East Pye Solar
Statement of Common Ground: Norfolk Wildlife
Trust

Revision 1
October 2026

Planning Inspectorate Reference: EN0110014

Document Reference: EXAM/9.7

Figure 8.3 Non-Statutory Designated Sites within 2km
 Index Sheet
 Revision A

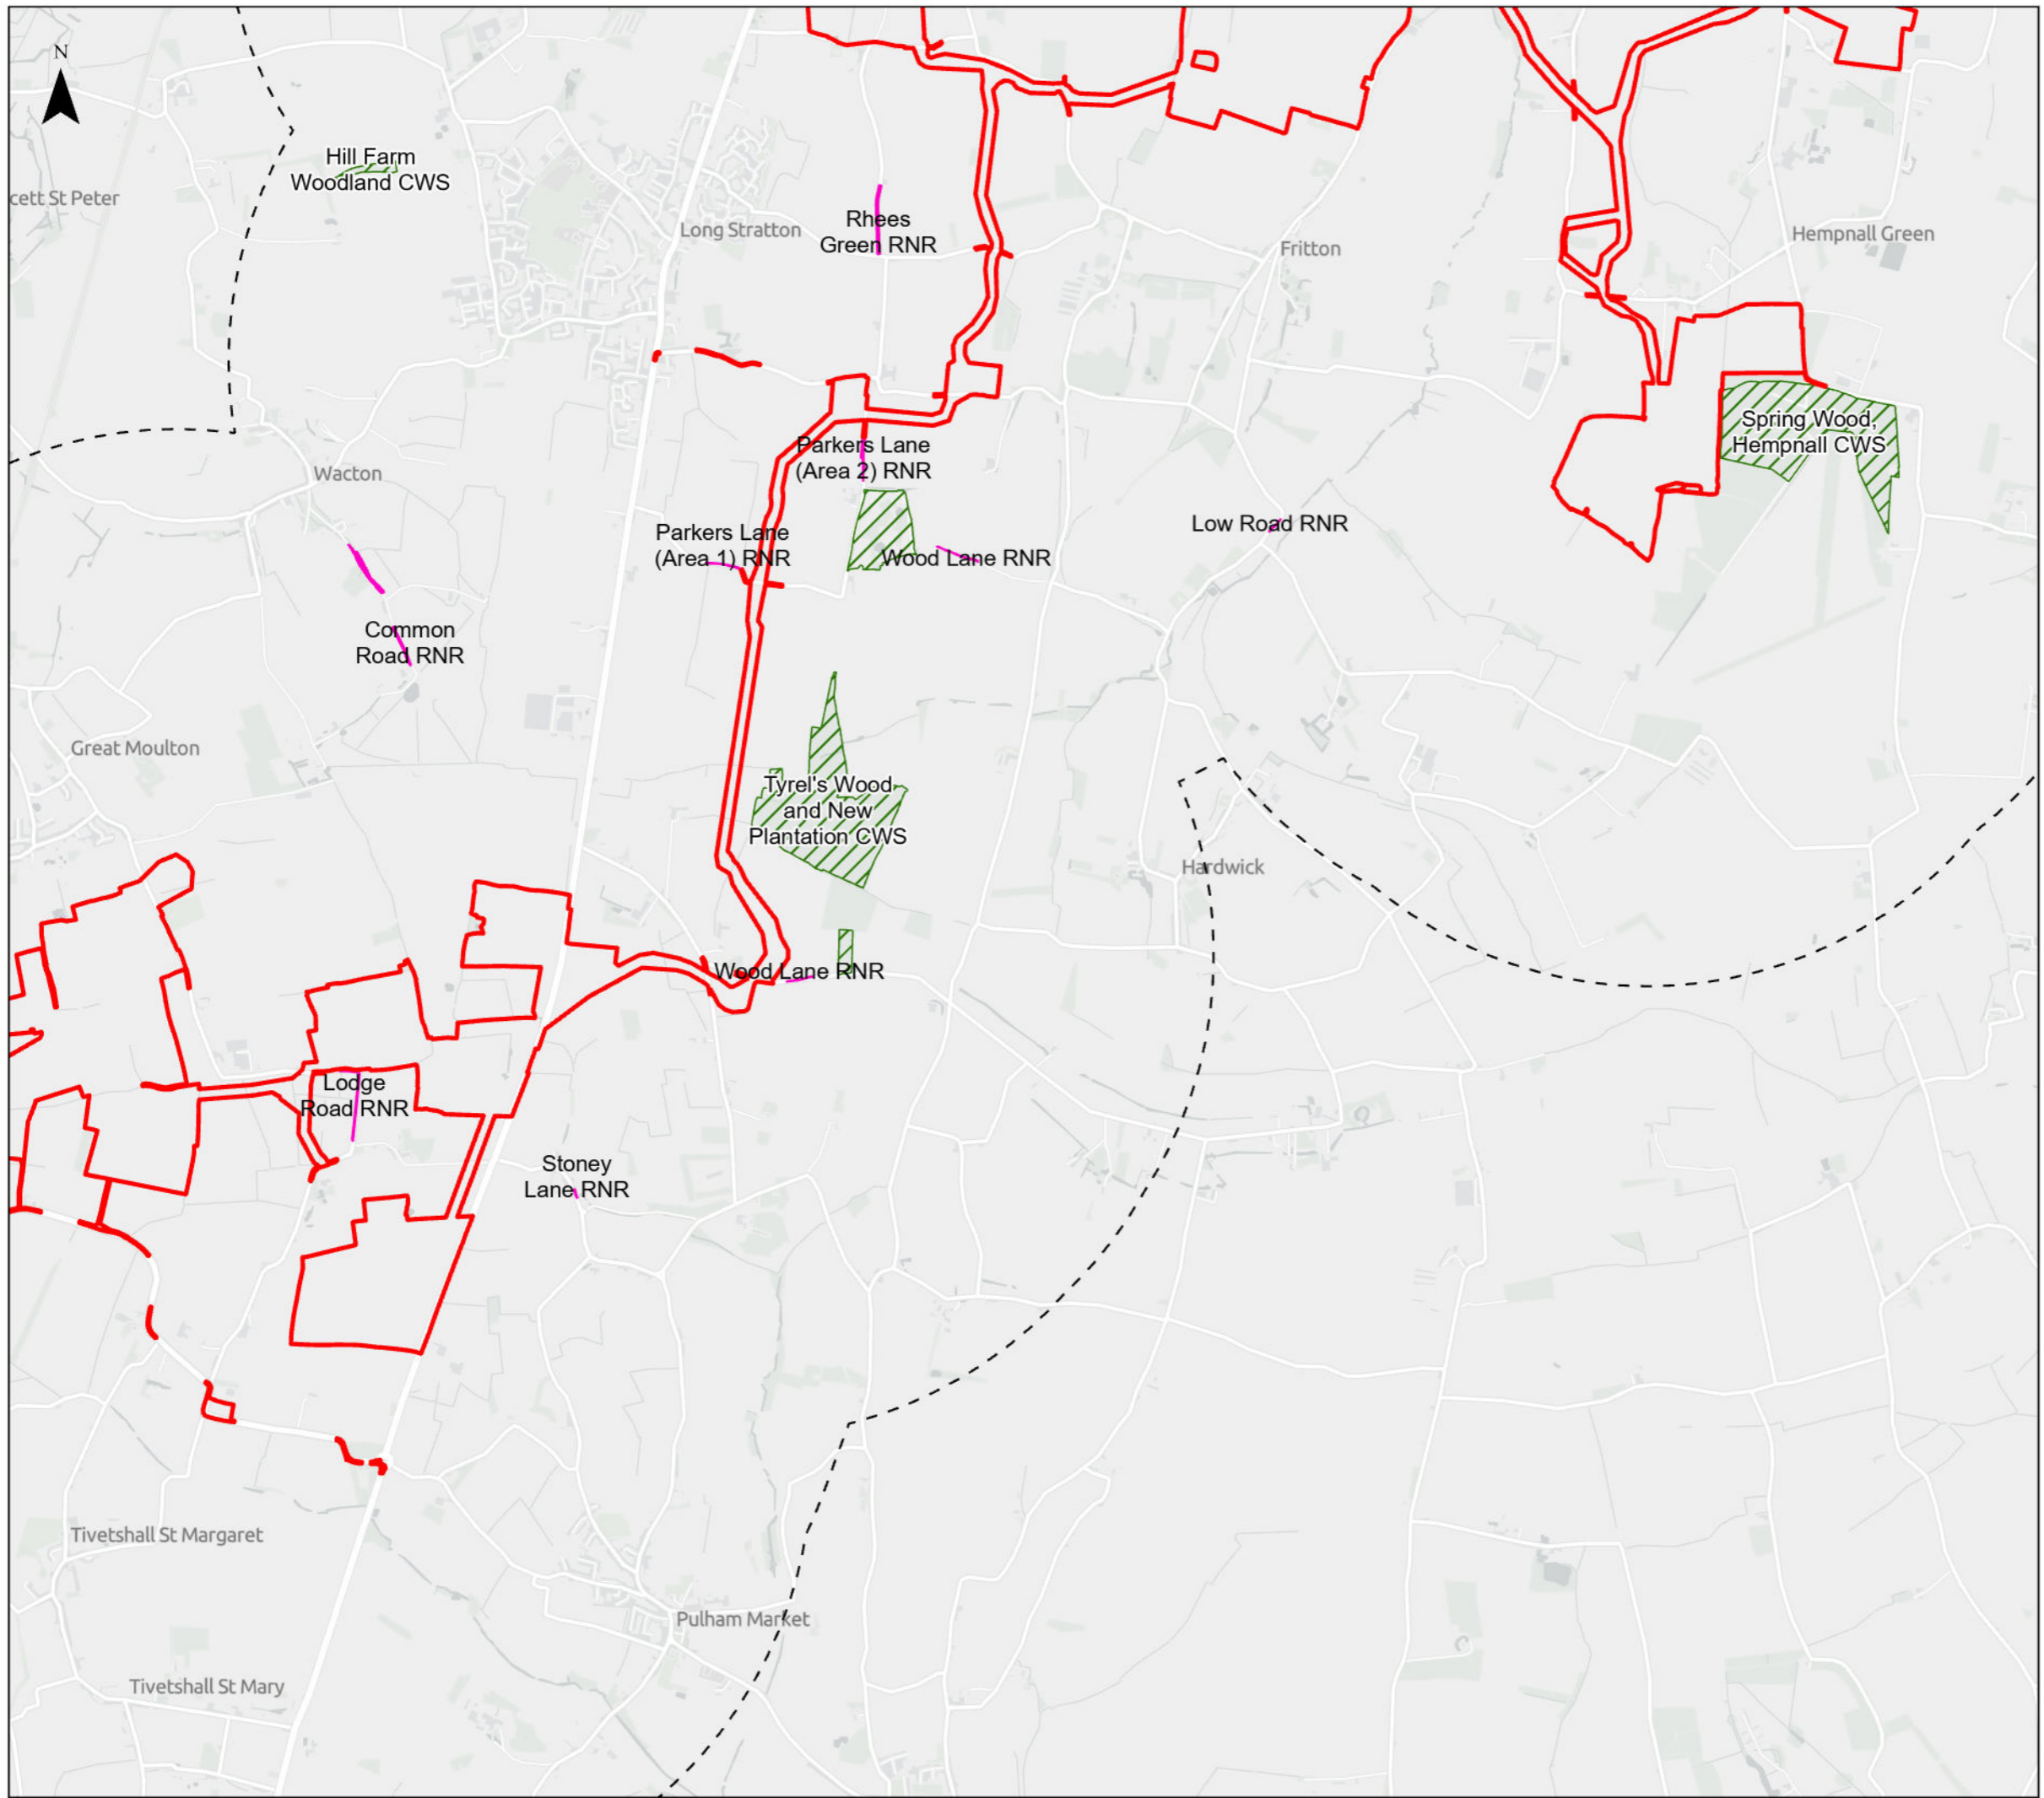
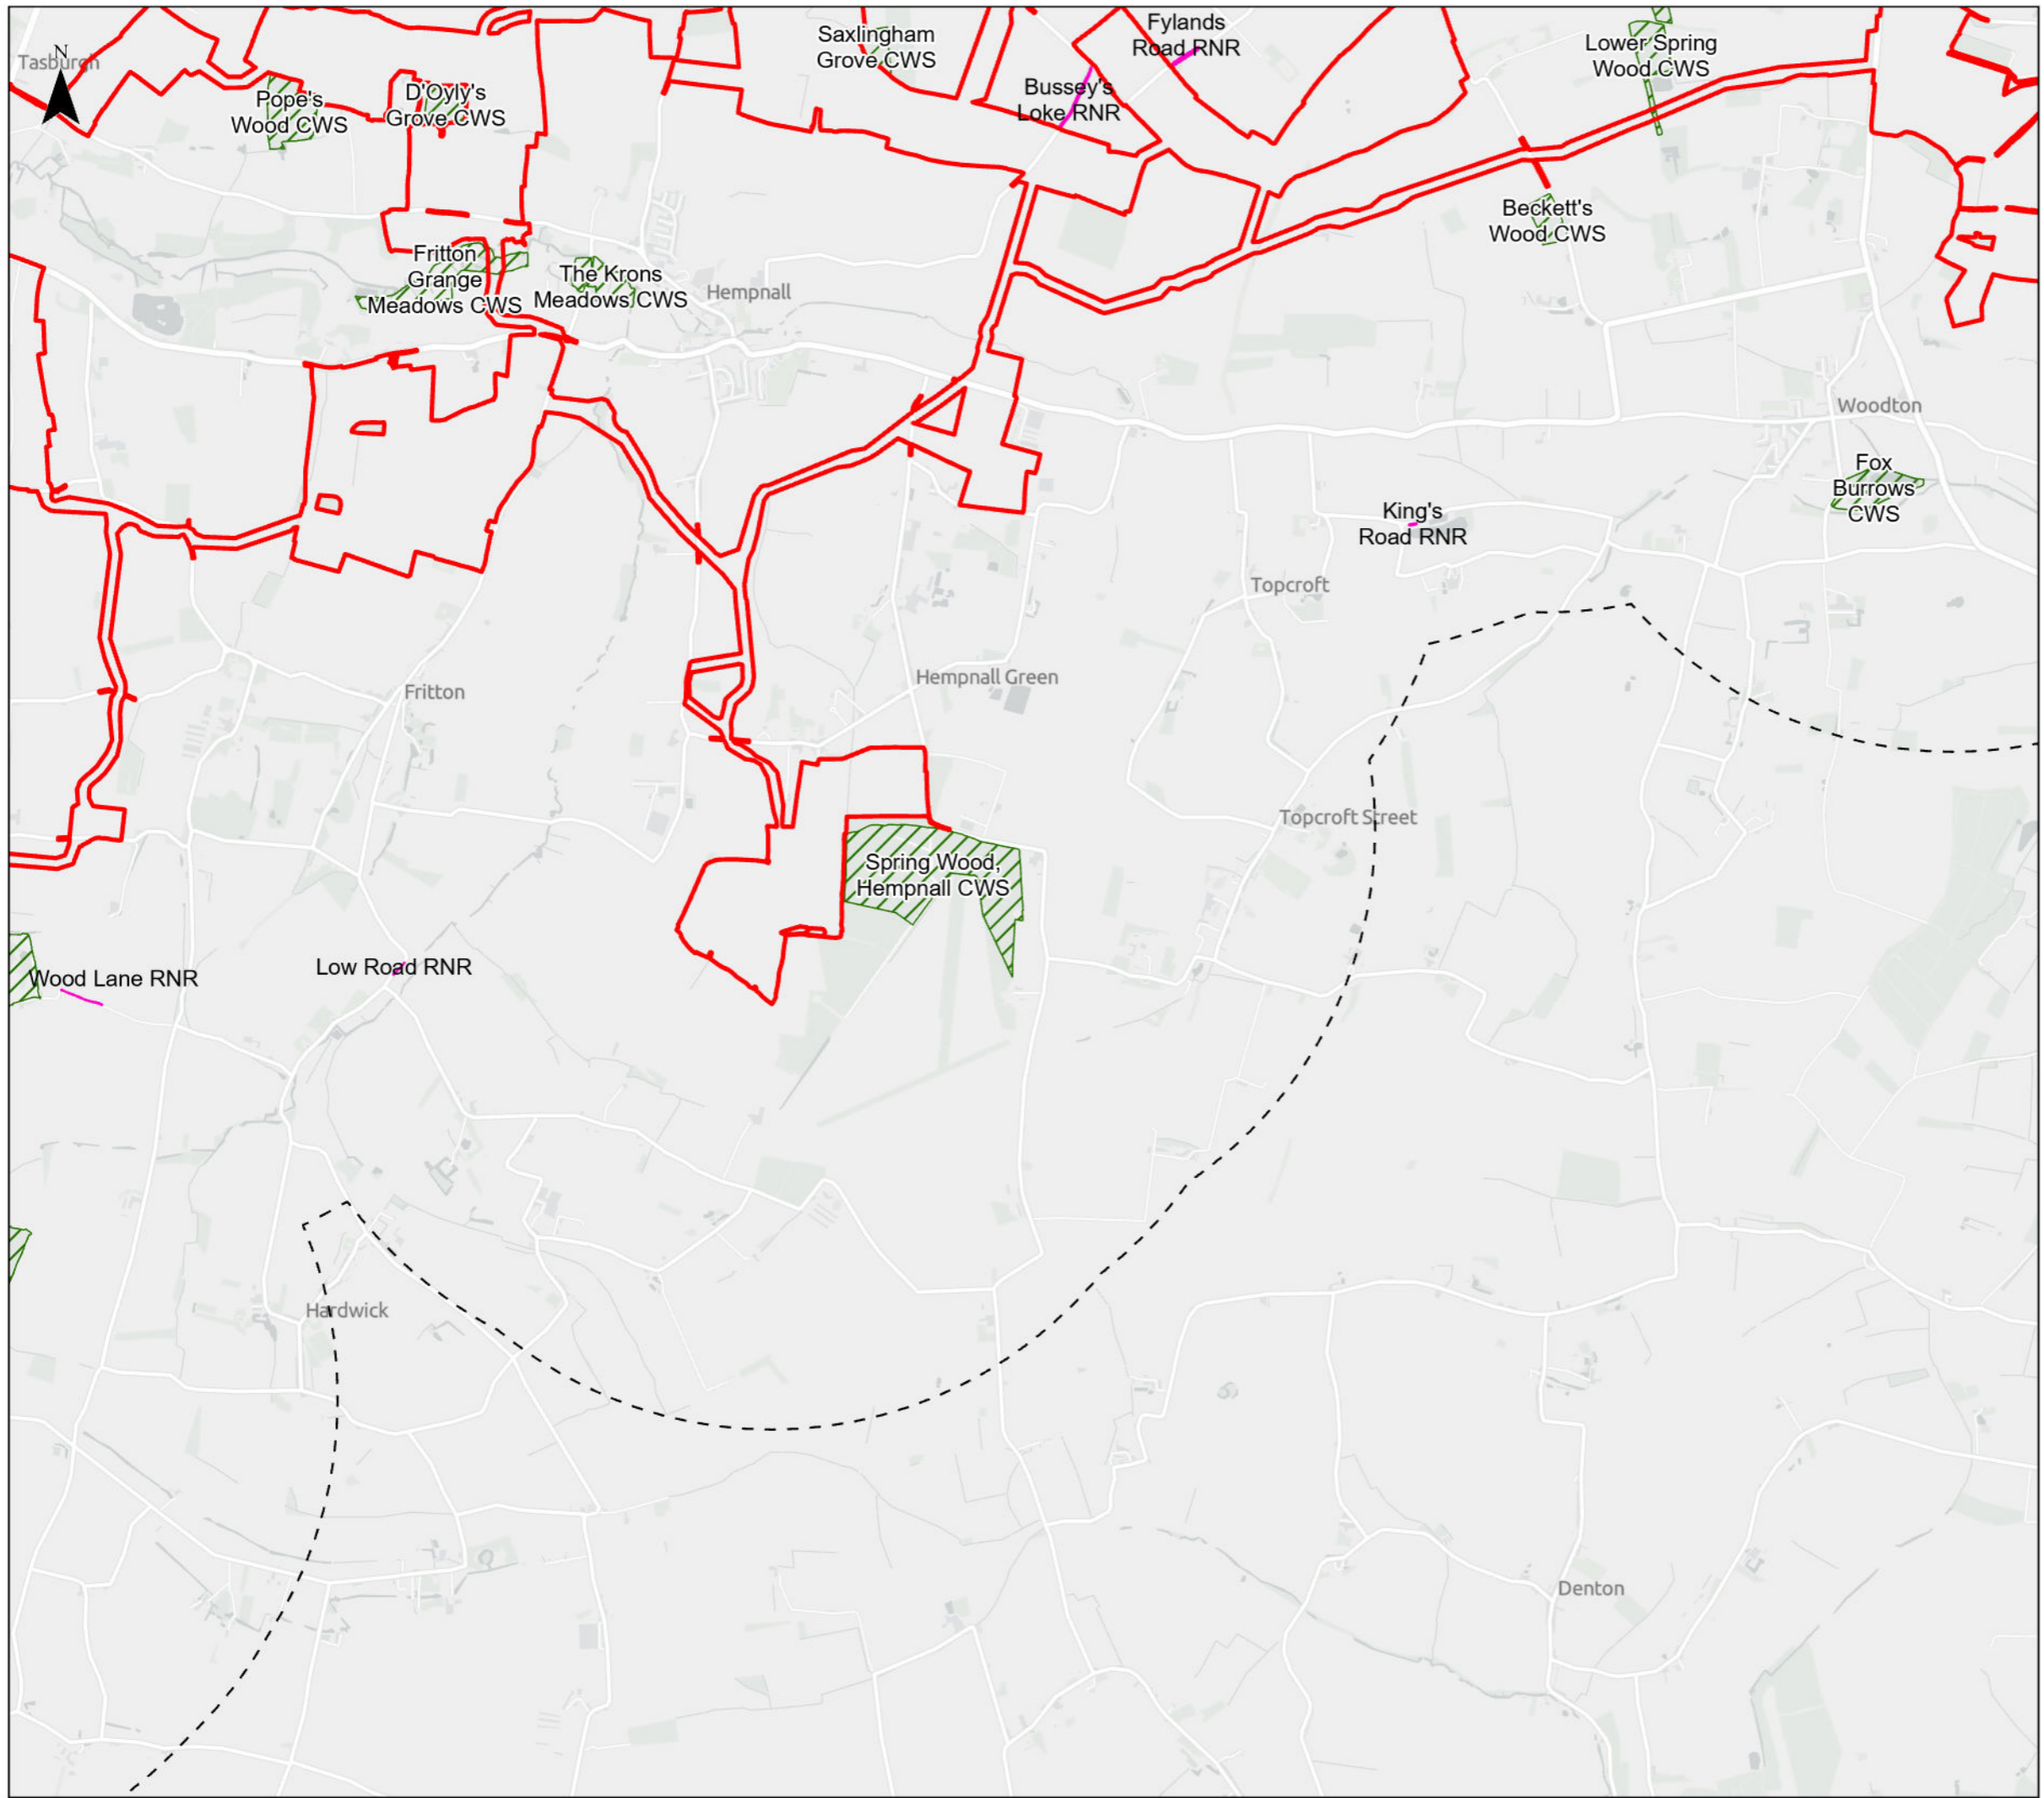
NWT EB - 4	Impacts on County Wildlife Sites and Roadside Nature Reserves	ES Volume 1, Chapter 8 – Ecology and Biodiversity [APP-044]	The Order Limits include parts of two County Wildlife Sites (CWSs) Lower Spring Wood CWS, and Fritton Grange Meadows CWS, and are adjacent/in the immediate vicinity of several others.	The Applicant is satisfied that the assessment set out between paragraphs 8.9.47 and 8.9.109 of ES Volume 1, Chapter 8 - Ecology and Biodiversity [APP-044] , has adequately assessed impacts to	Under discussion

The Order Limits also include or adjoin several Roadside Nature Reserves (RNRs), including Bussey's Loke, Market Lane and Parker's Lane. While the applicant proposes to cross both CWSs using Horizontal Directional Drilling (HDD), critical details remain unresolved. The Outline Construction Environmental Management Plan (oCEMP) confirms that the precise locations of HDD entry and exit points will only be determined at the detailed design stage.	County Wildlife Sites (CWSs) and Roadside Nature Reserves (RNRs). The Scheme has designed out impacts to these sensitive sites through run-off control, pollution prevention and dust control during construction which will be secured by the Outline CEMP [APP-196]. Stand-off distances of 30m from the CWSs and the adoption of Horizontal Directional Drilling (HDD) will mitigate impacts. As per Section 4.4 of the Outline Cable Route Construction Statement [APP-216] the technology used for the HDD will be determined by feasibility studies carried out at each crossing during the detailed design stage and in accordance with a method statement. The embedded design principles adopted and detailed within the Design Principles, Parameters and Commitments [APP-213] have been applied to protect CWS, and commit to specific CWS avoidance areas; this will include HDD entry and exit points.
